From: Tom Leonard
To: [Robin Proebsting](#)
Cc: "[Marianne Leslie \(mleslie.lldev@gmail.com\)](mailto:Marianne.Leslie.(mleslie.lldev@gmail.com))"
Subject: File No. SUB19-002, B&G Club proposed development
Date: Wednesday, May 8, 2019 4:56:14 PM

PRELIMINARY UTILITY PLAN
2825 W MERCER WAY
 PRELIMINARY PLAT
 PARCEL #2174502425
 CITY OF MERCER ISLAND WASHINGTON

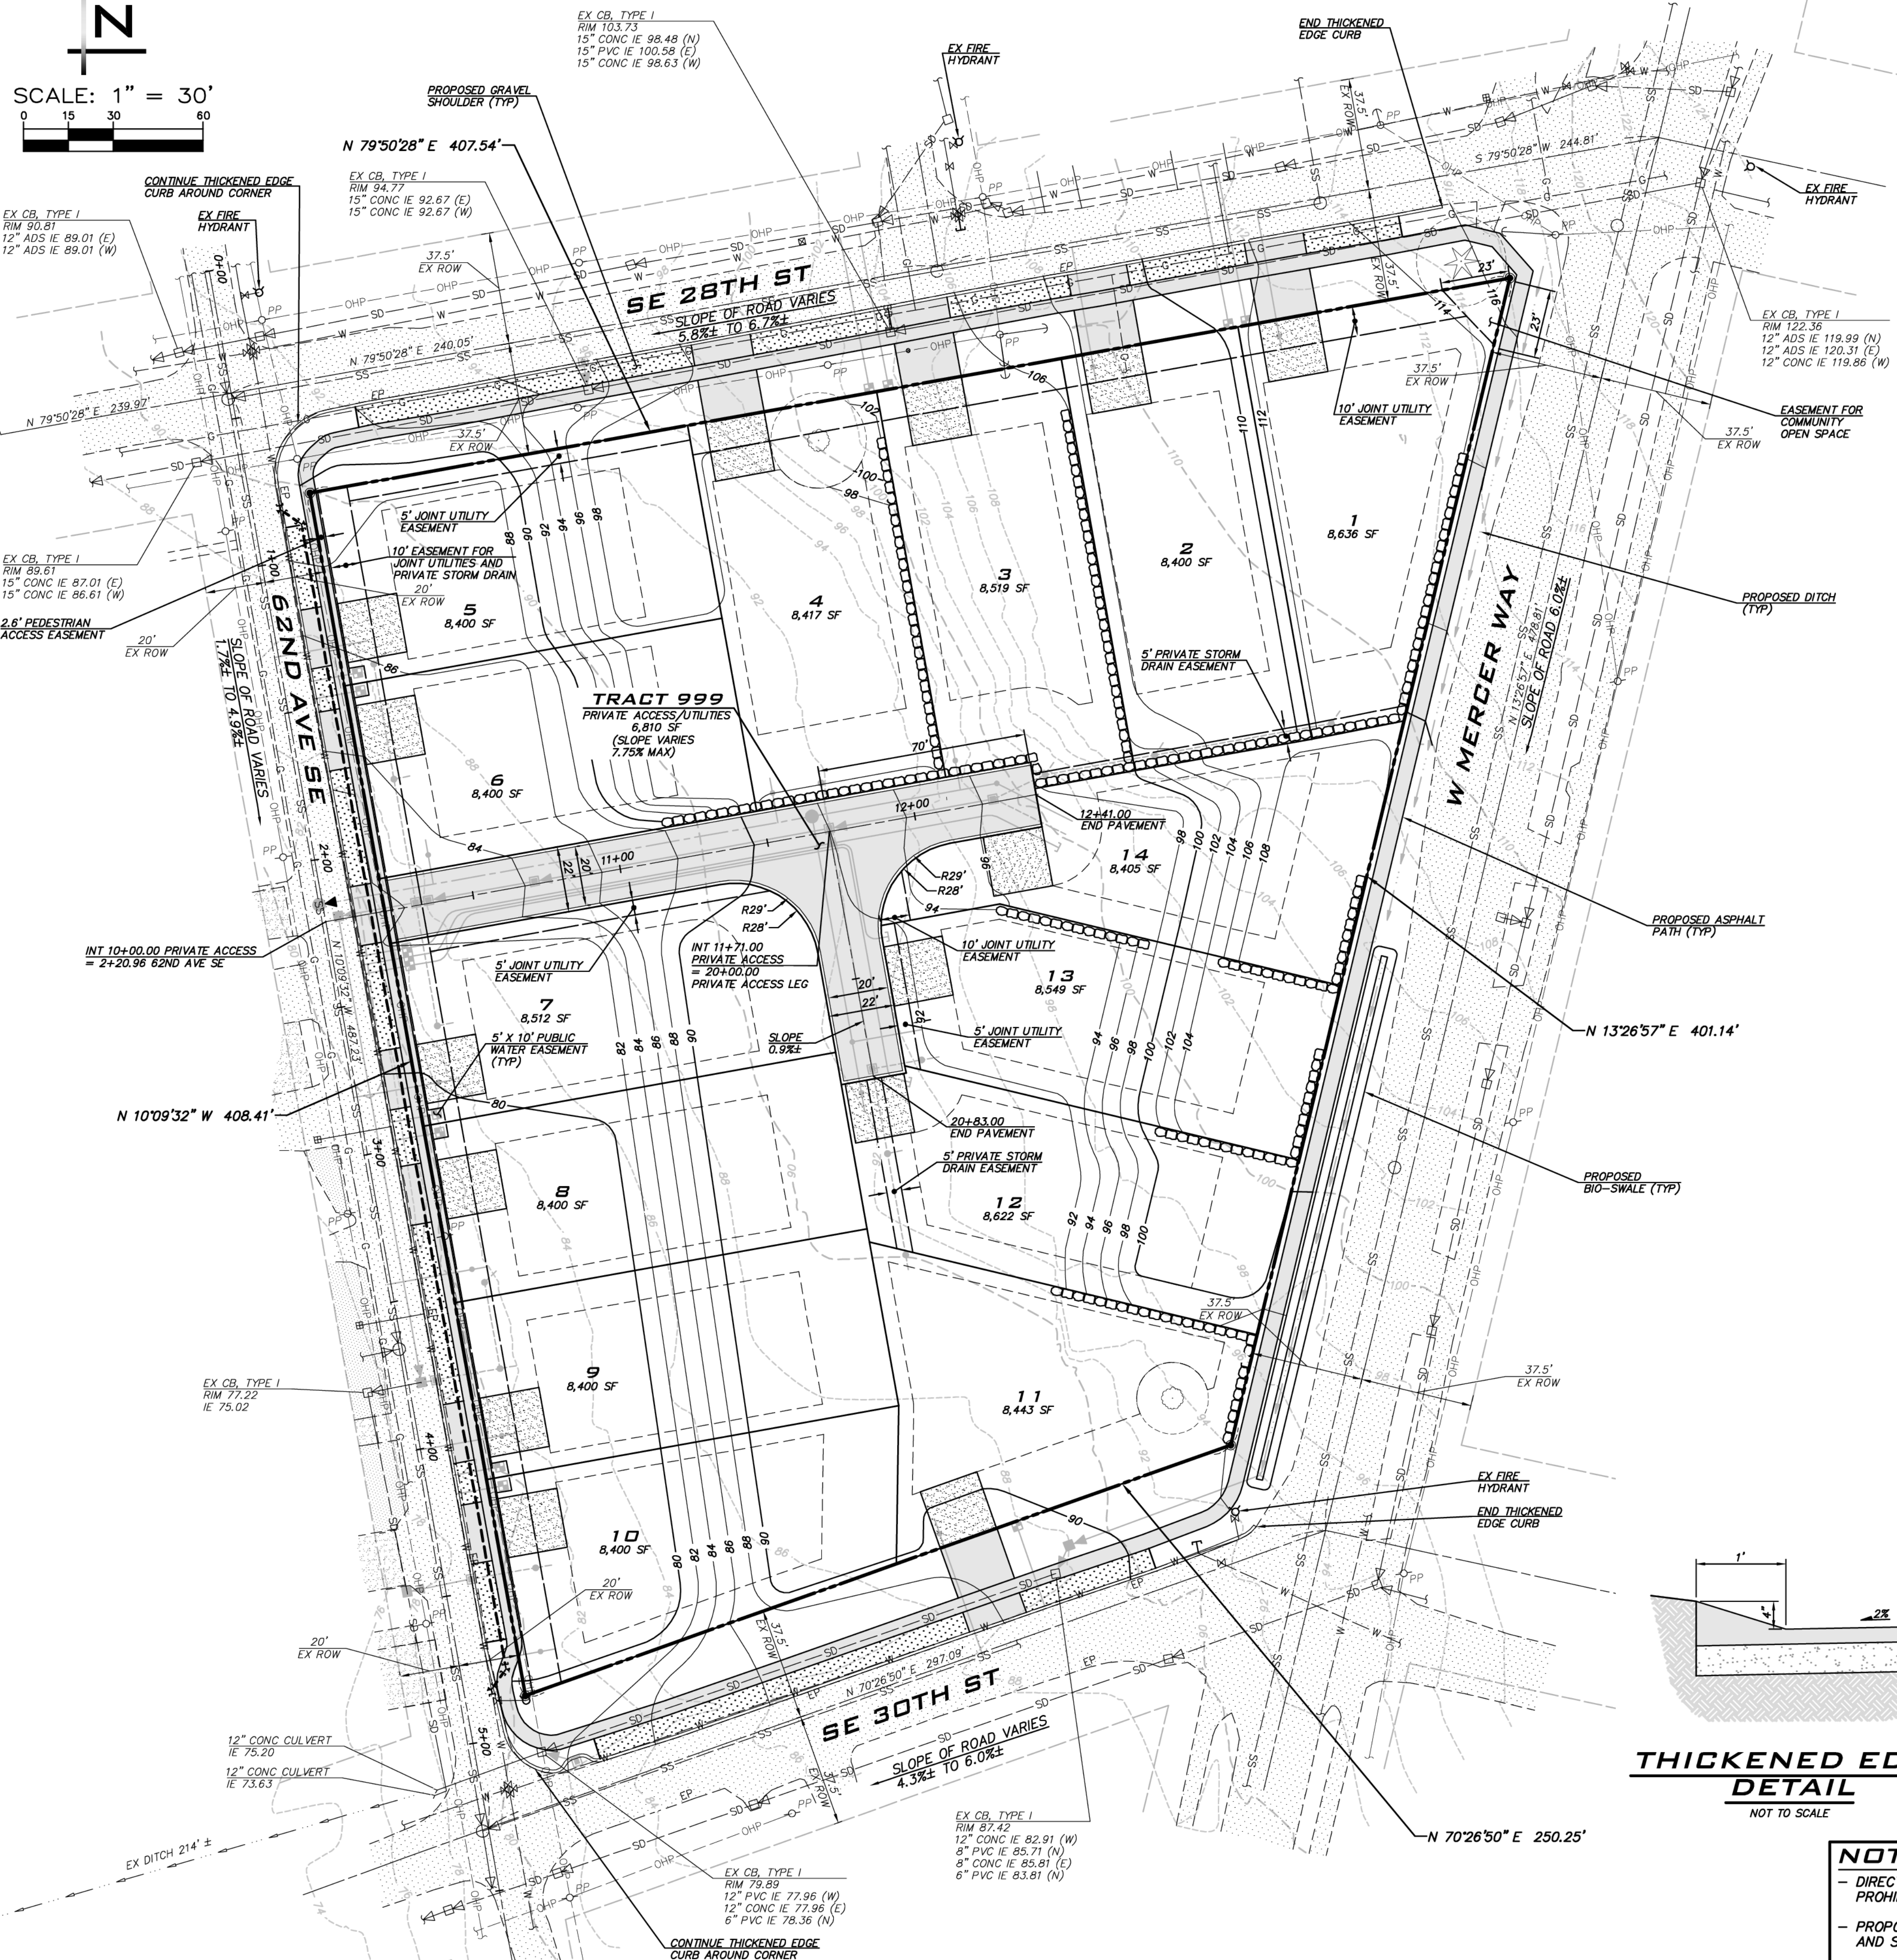
2. Most cities in our area require developments of "long plats" to improve the infrastructure surrounding the proposed development. From what I have seen, it is difficult to tell whether or not that is being required. From the submittal maps (which do not have "keys" to show what lines & dashes mean), it does not appear to show sidewalks, storm drainage system, retention ponds, or homesite water treatment for the run off on roofs, driveways, and proposed street.

6. This project is located just two blocks from the shores of Lake Washington. The high density of this subdivision should be required to have a water treatment system for all impervious surfaces

(roofs, patios, driveways, roadway...) before the water connects to the existing downstream drainage system, which then flows into Lake Washington. These water treatment systems are a retention pond or vault, and is the current technology being used in cities nearby. If there is no community water treatment, will each home in the subdivision be required to have its own water treatment system before water is "dispersed" into the current downstream drainage, which eventually goes into Lake Washington?

**PRELIMINARY ROAD PLAN &
SECTIONS**

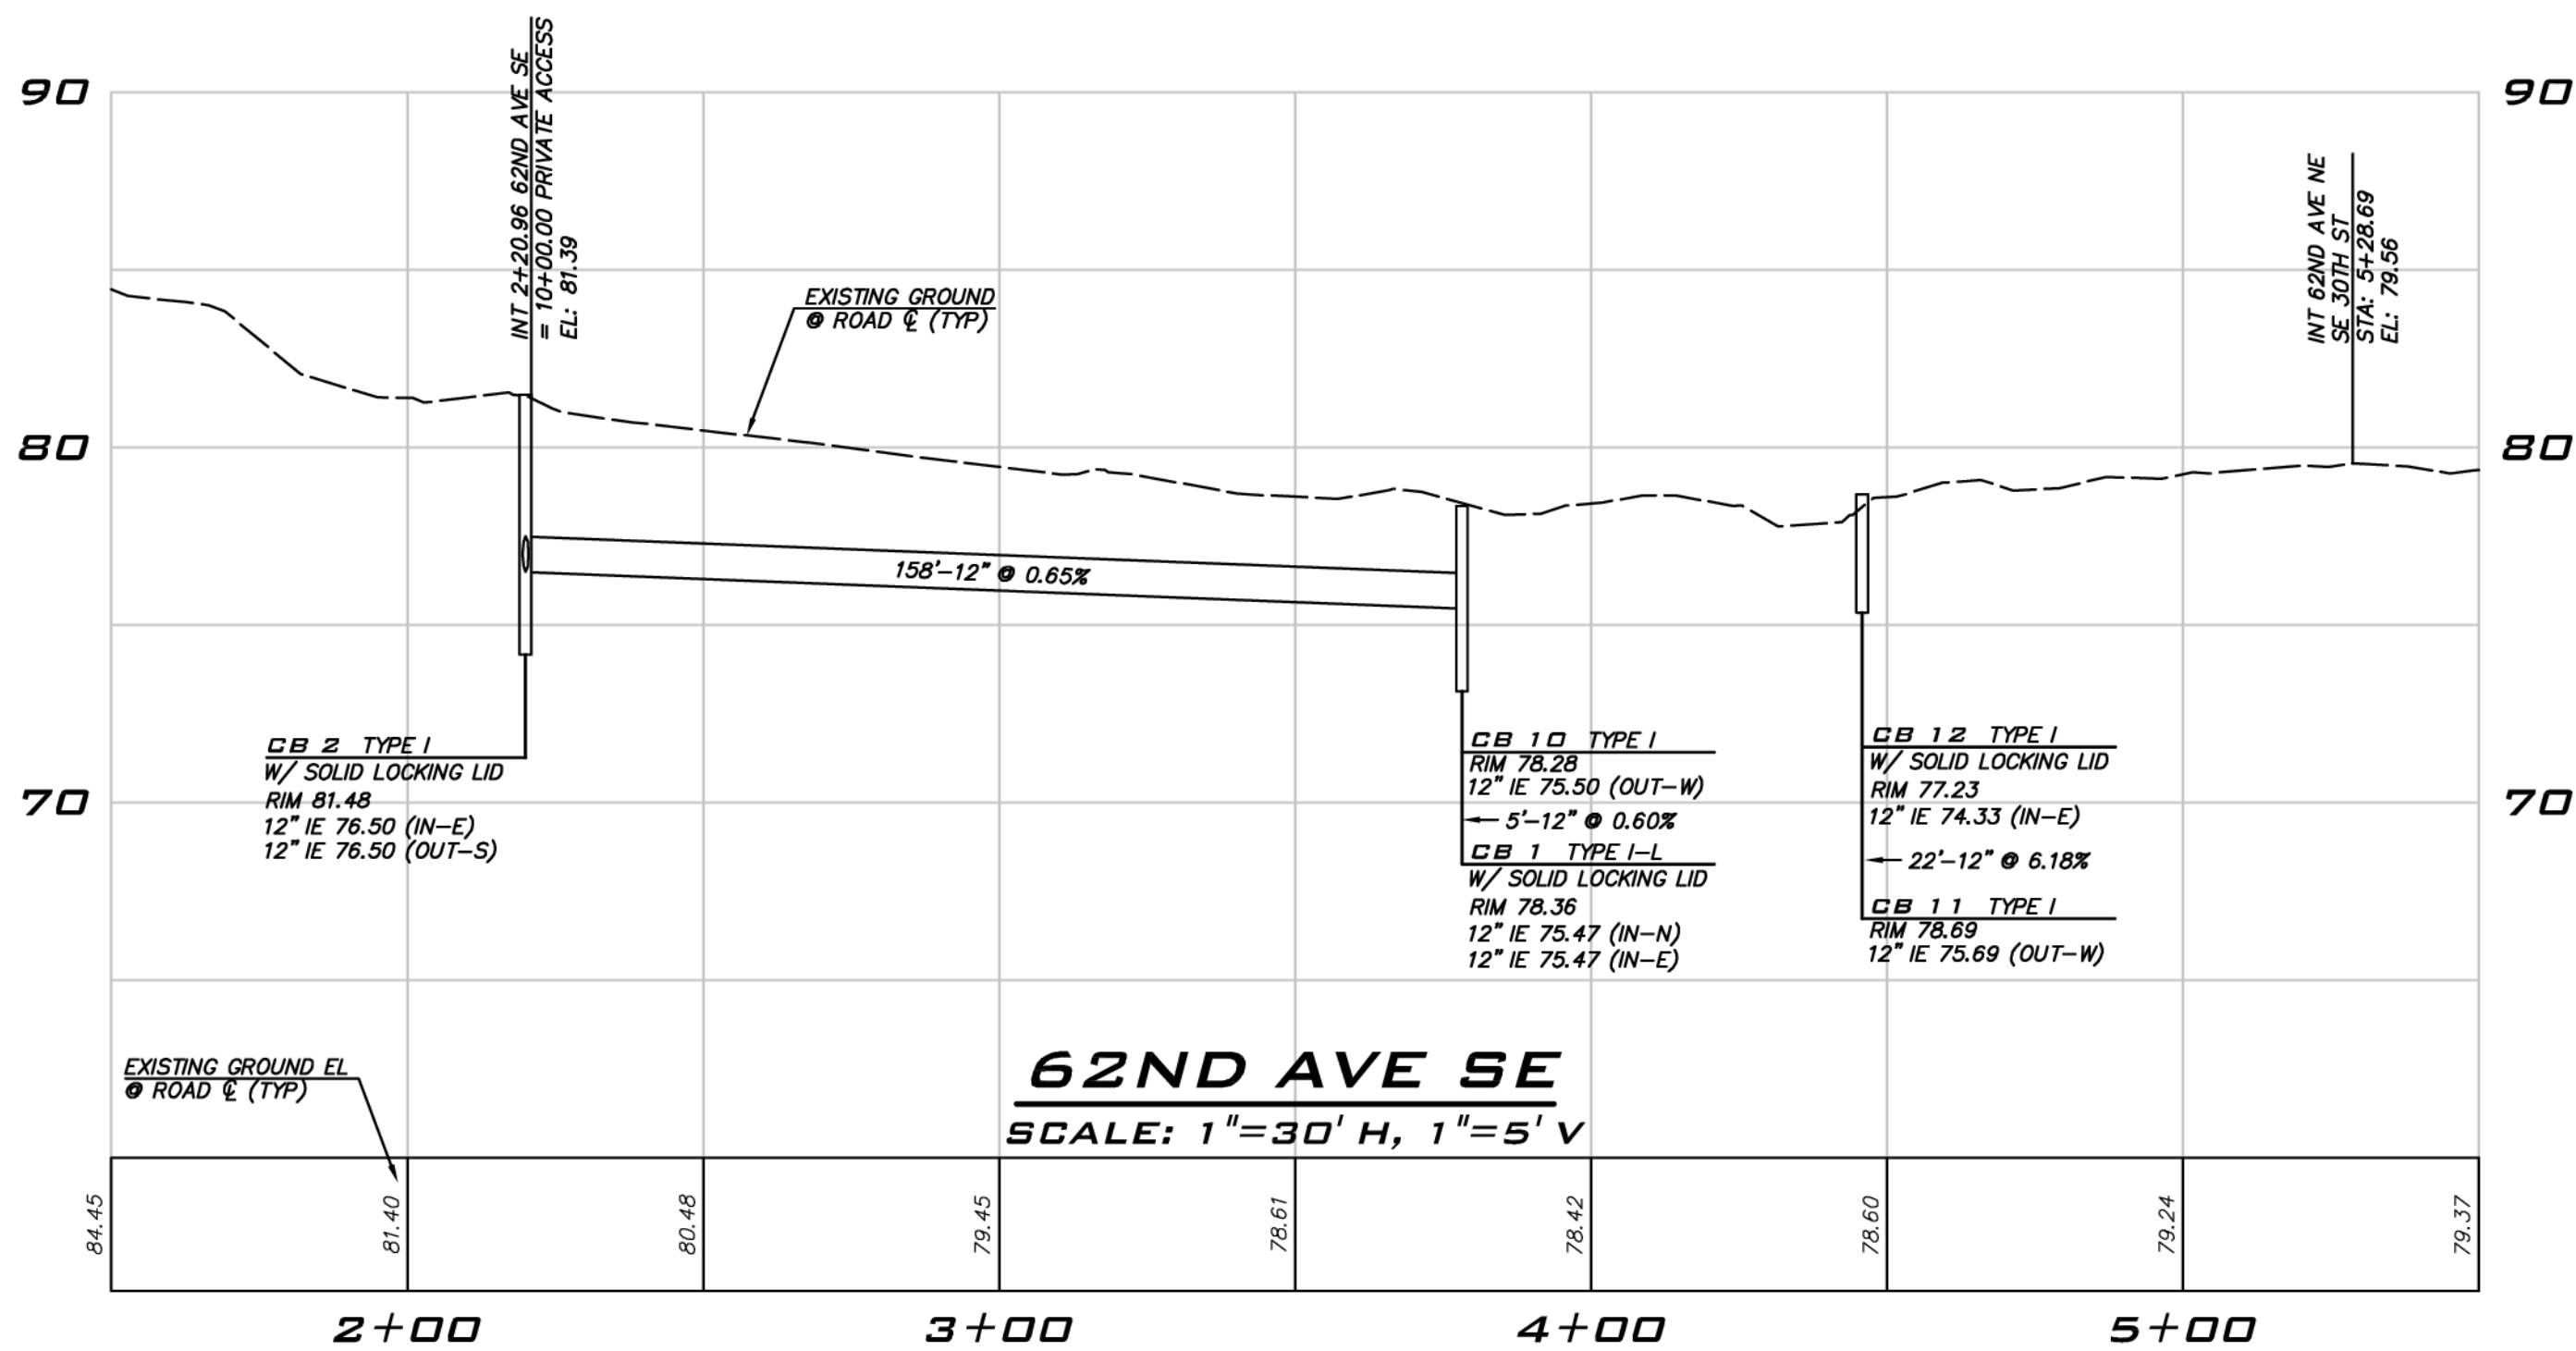
7. The detail for the proposed street entering the subdivision from 62nd Ave SE appears to not have any turnaround for emergency vehicles. I believe there is always a requirement for new developments that allow enough room for fire trucks and other emergency vehicles to enter and turnaround. Shouldn't this be a requirement for this subdivision?

PRELIMINARY TREE RETENTION AND REPLACEMENT PLAN
2825 W MERCER WAY
PRELIMINARY PLAT
 PARCEL #2174502425
 CITY OF MERCER ISLAND WASHINGTON

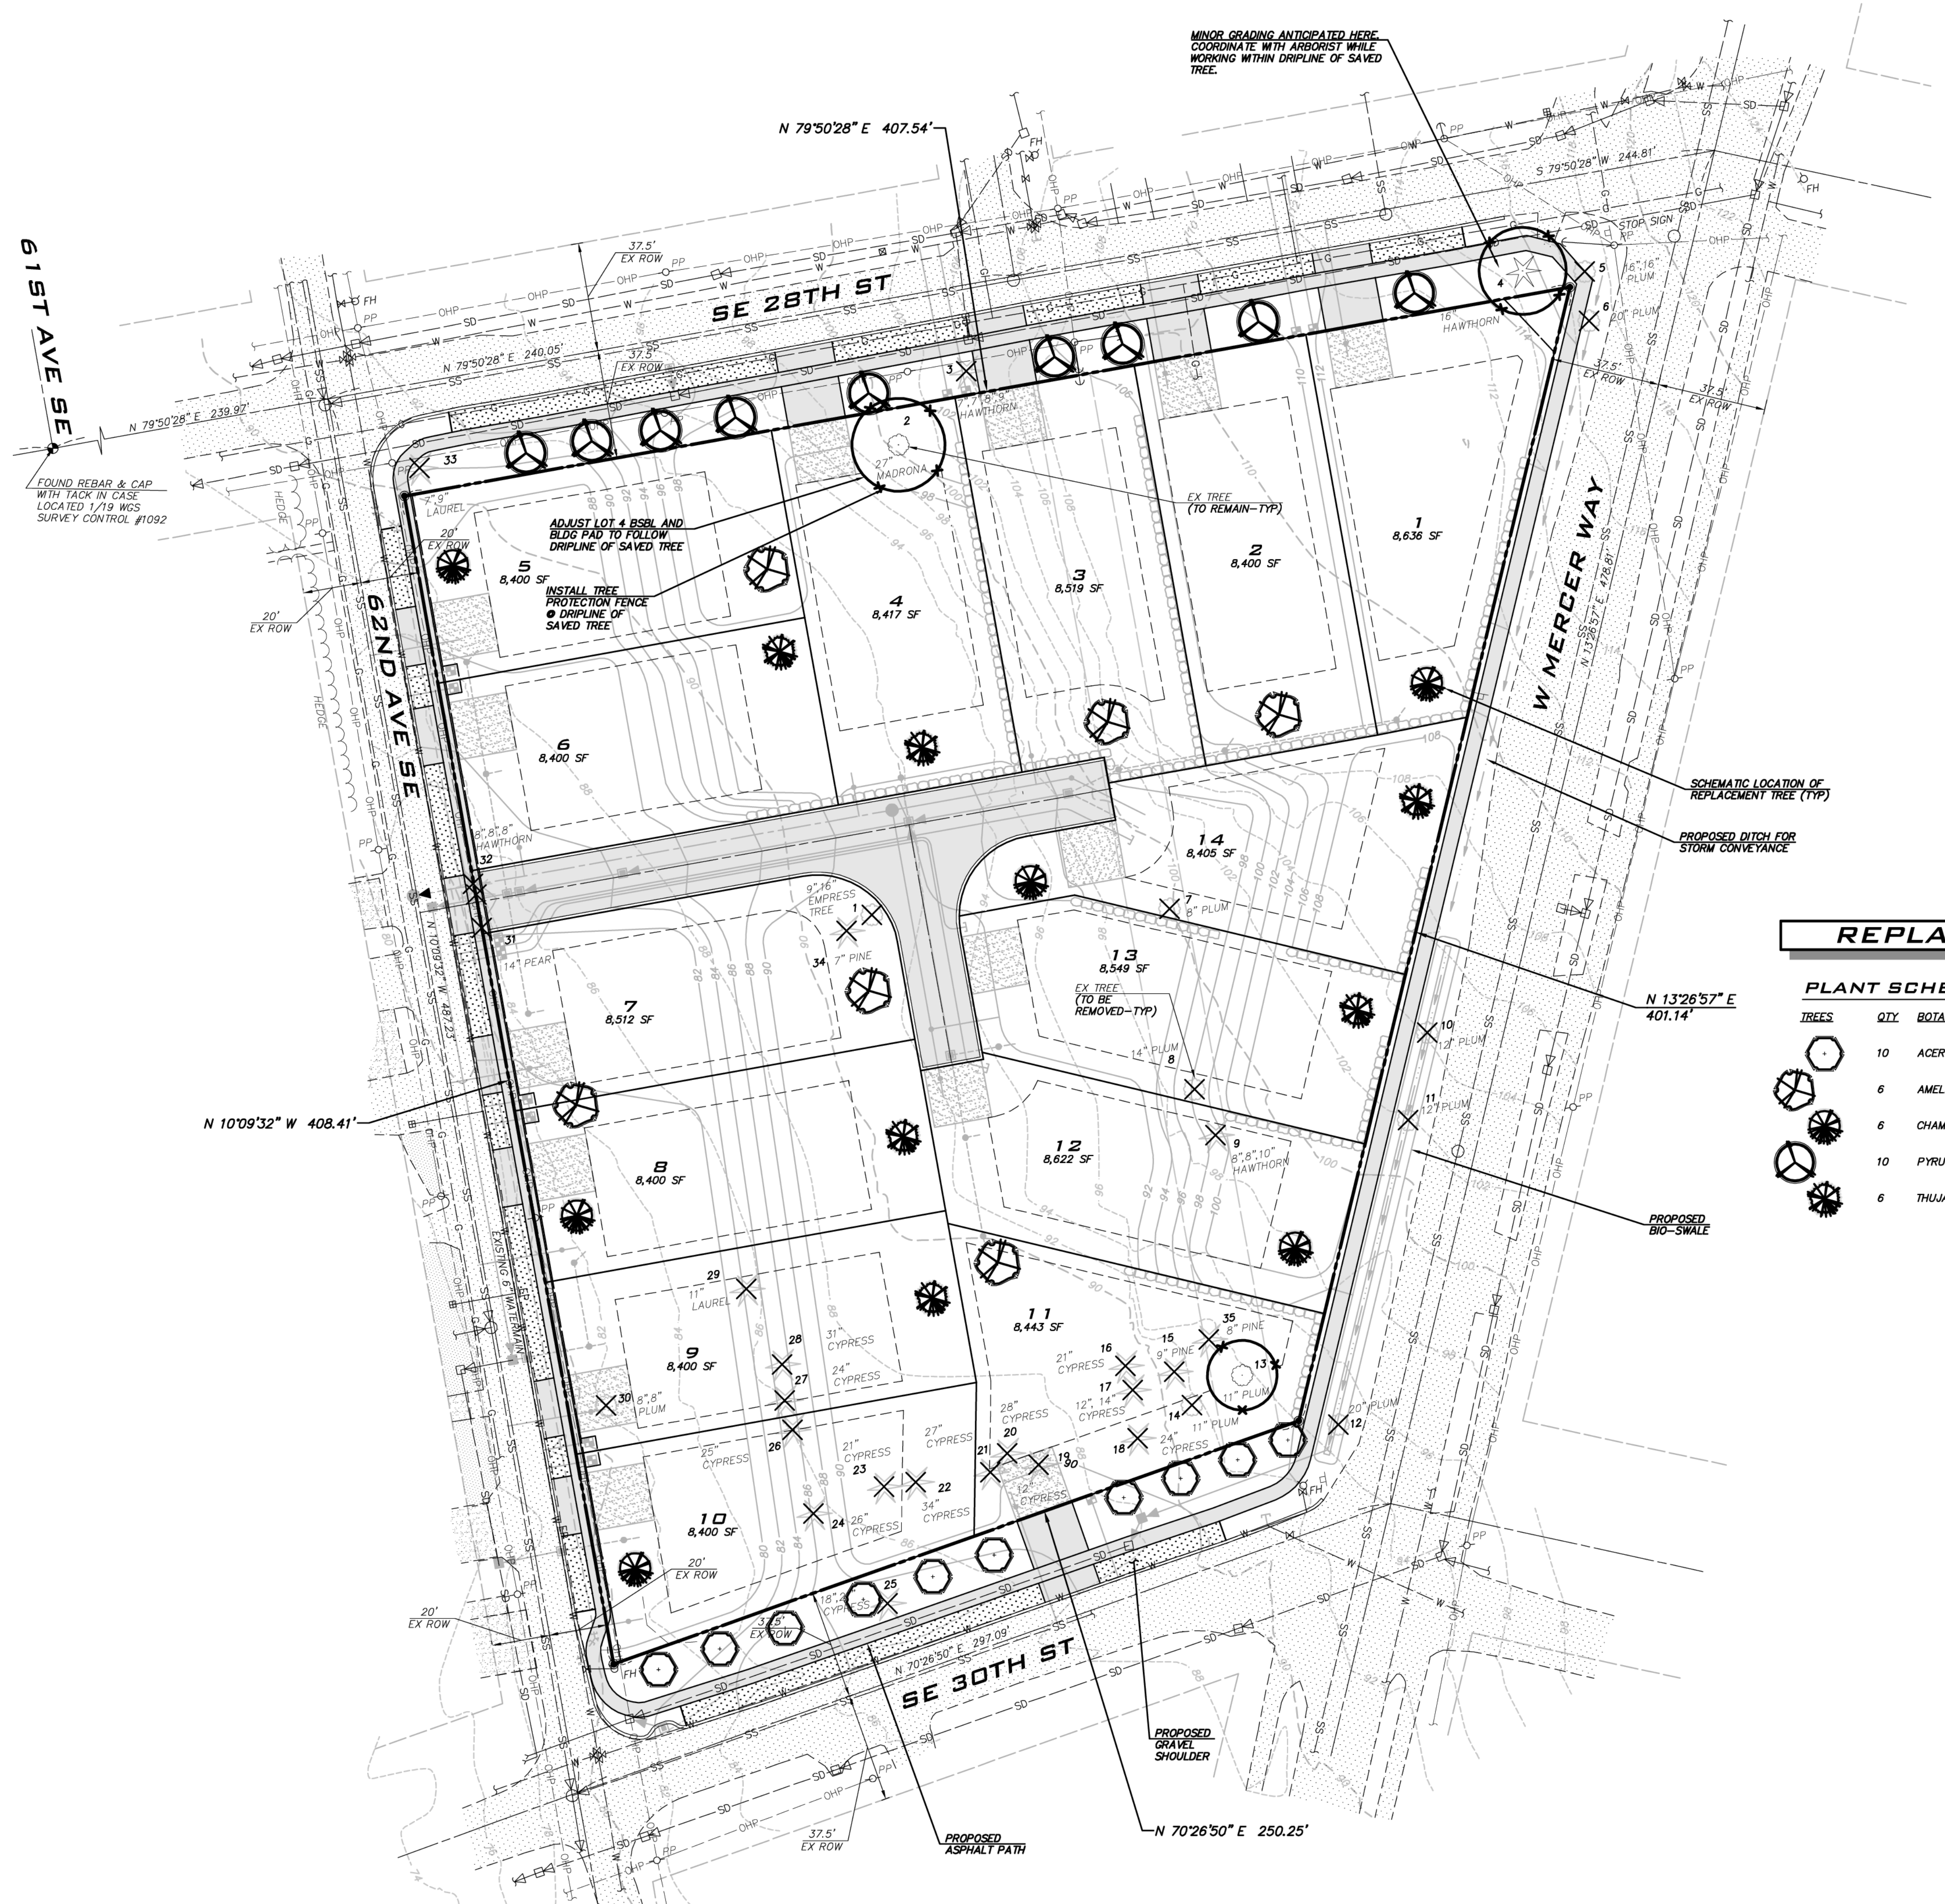
3. What will the height of the homes be in this subdivision? How will that be measured? Existing grade, median grade, or some other version?
4. With the removal of current trees to make way for construction, will there be a height limitation on the newly planted trees so surrounding properties can maintain their current views? There are an abundance of trees that are "dwarf" in size which could be used without negatively affecting current view corridors.
